City of Albuquerque Stormwater Construction Site Inspection Report

General Information					
ESC File No.	M09E025A	Project Name:	Sage Ranch Subdivision		
NPDES Id. No.	NMR1004GM	Location:	9600 Sage Ranch Ct. NW		
12/28/2023	Owner	Contractor			
Operator	Sage Ranch , LLC	Westway Homes			
Contact name & title	Mike Feetz	Mike Feetz			
e-mail	mike@thewestway.com	mike@thewestway.com			
Contact Phone #	379-5368	379-5368			
COA Inspector	Doug Hughes	Start/End Time:	10am		
Construction Phase:	House Construction				
Type of Inspection:	<input type="checkbox"/> Regular	<input type="checkbox"/> Storm Event	<input type="checkbox"/> Past Storm Event >0.25"	<input type="checkbox"/> 311/Complaint	<input checked="" type="checkbox"/> Follow Up
Weather at time of inspection?		clear		Temperature:	~ 40
Estimated date of last storm 0.25" or greater		12/23/2023

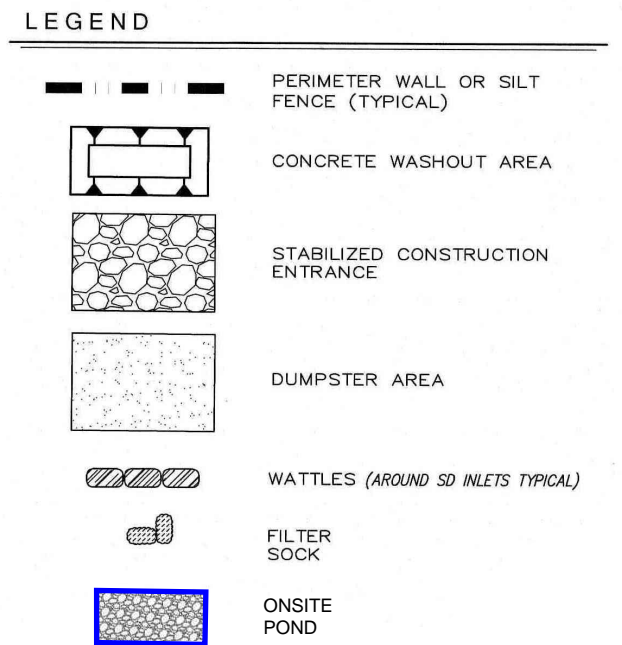
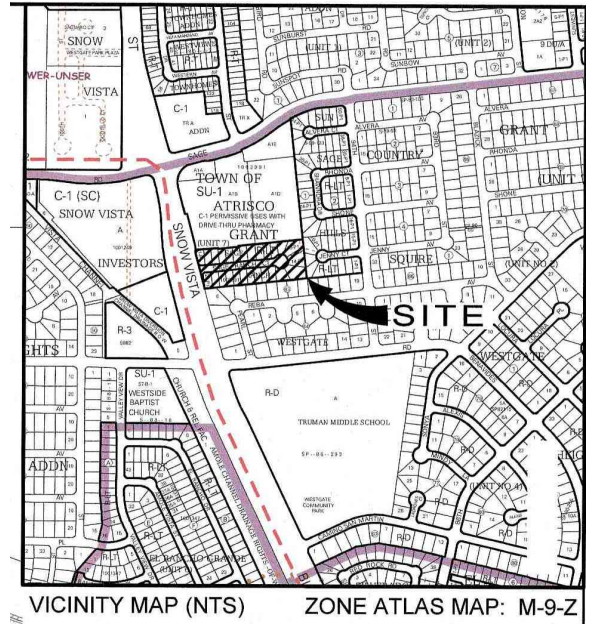
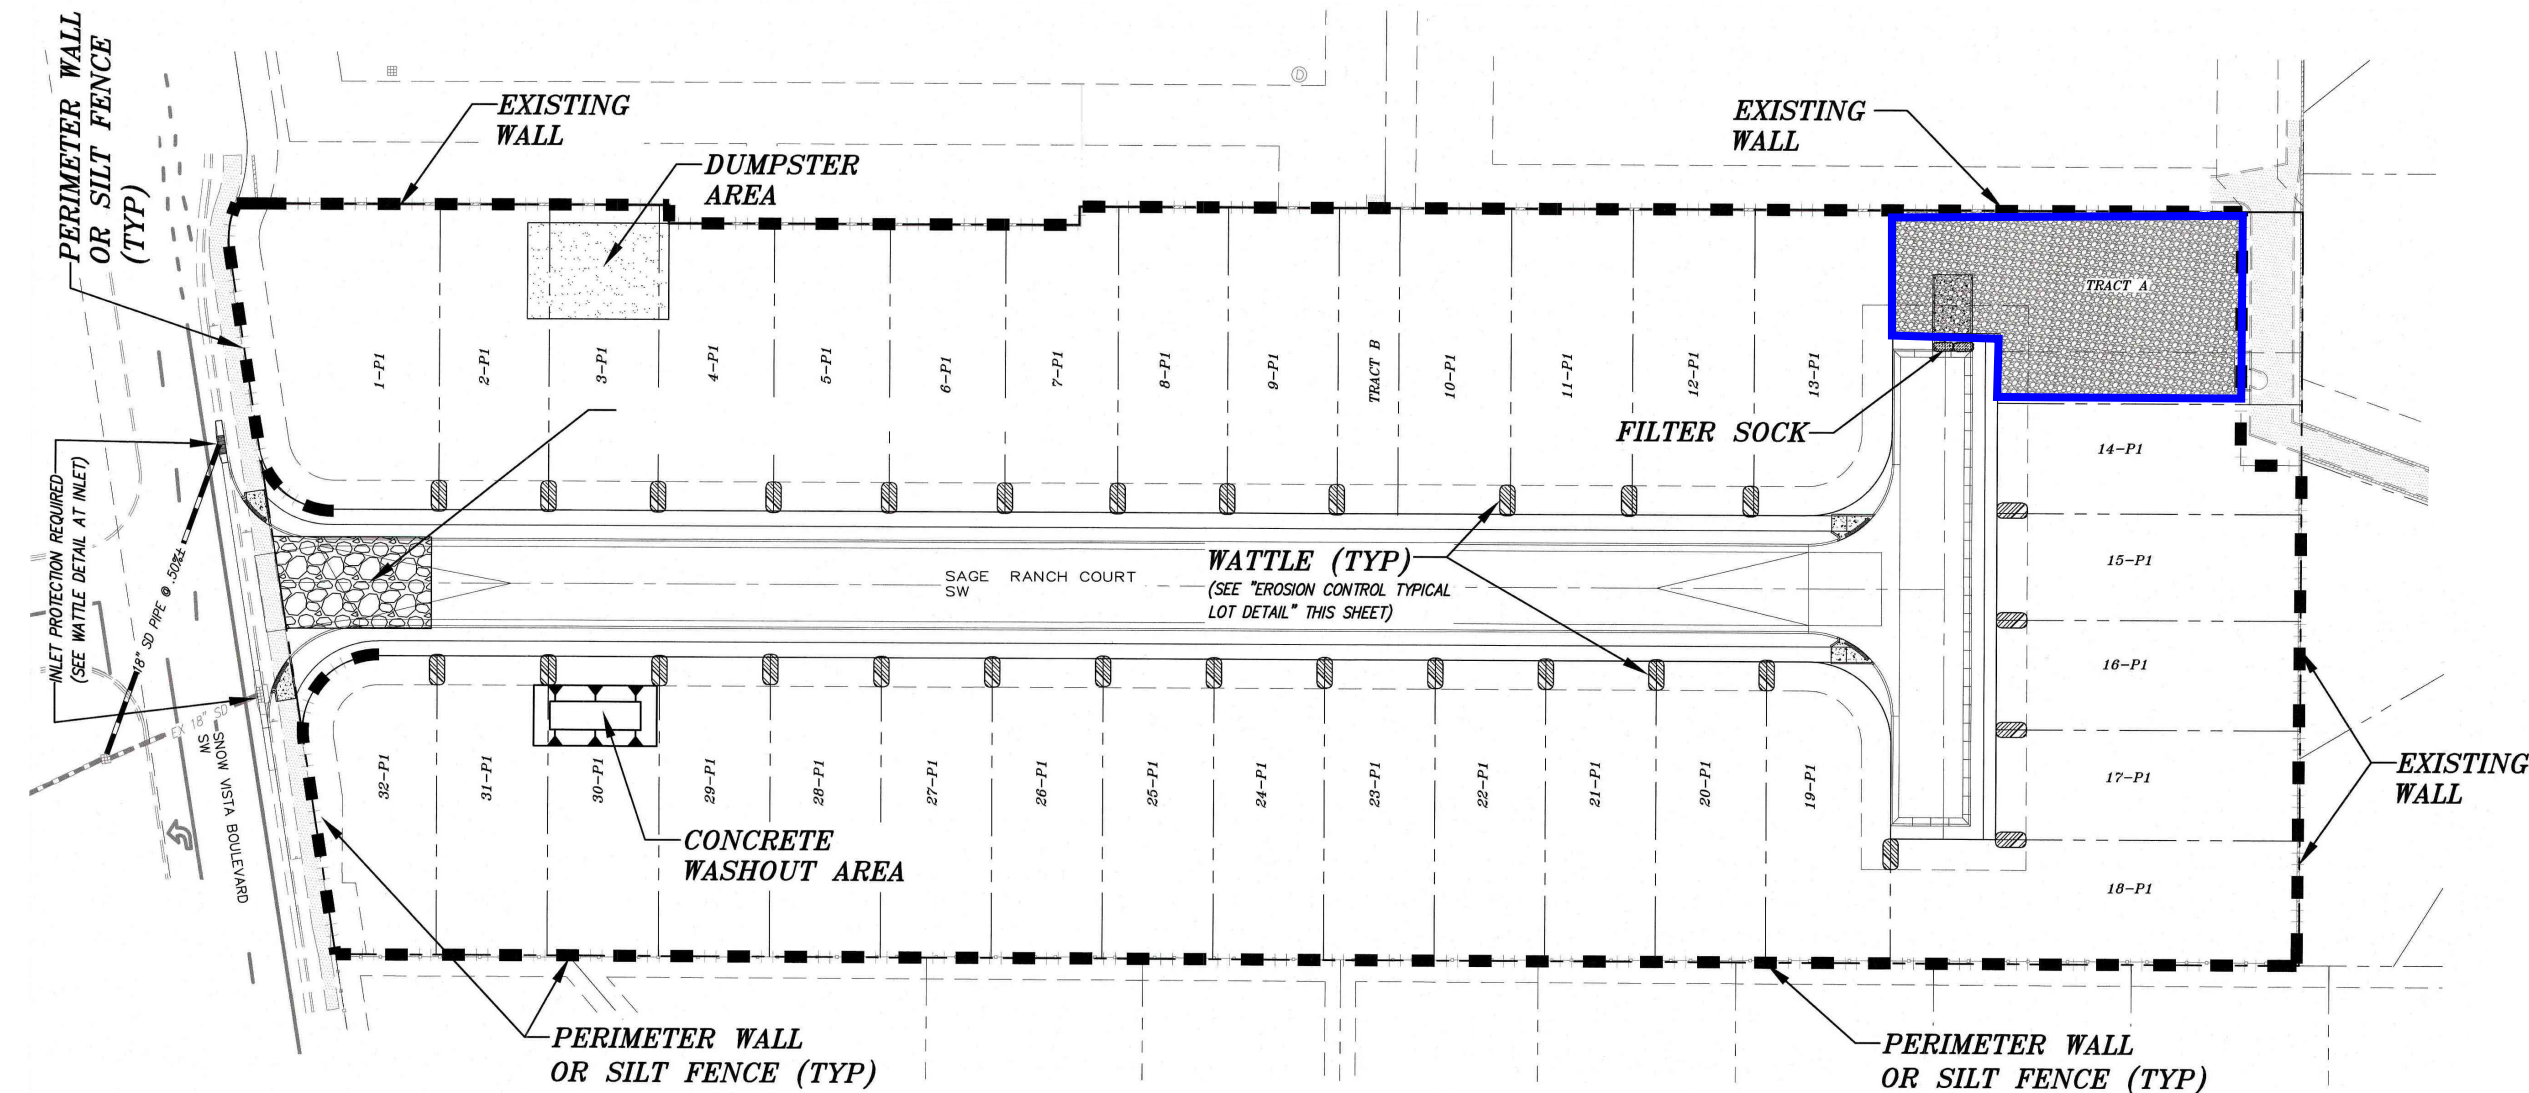
Item Number	Deficiency/ Corrective Action				
1	1. The SWPPP map wasn't up-to-date, because it didn't identify the lots where construction was complete, BMPs had been removed, and the lots had been transferred to the new homeowner. The first informal notice of a SWPPP violation was emailed to you on 1/27/2022 and the second on 11/30/23. Required Mitigation: The SWPPP, including the SWPPP map, Self Inspection Reports and Corrective Action Reports, must be kept up-to-date per CGP 7.1 and available on-site per CGP 4.7.3, 5.4.3 and 7.3.				
2	Sediment was present in the street and had not been removed in violation of CGP 2.2.4.d. Required mitigation: Where sediment has been tracked-out from your site onto paved roads and sidewalks, you must remove the deposited sediment by the end of the same business day. Remove the track-out by sweeping, shoveling, or vacuuming these surfaces or using other similarly effective means of sediment removal. You are prohibited from hosing or sweeping tracked-out per CGP 2.2.4.d. CGP 2.2.4.d.
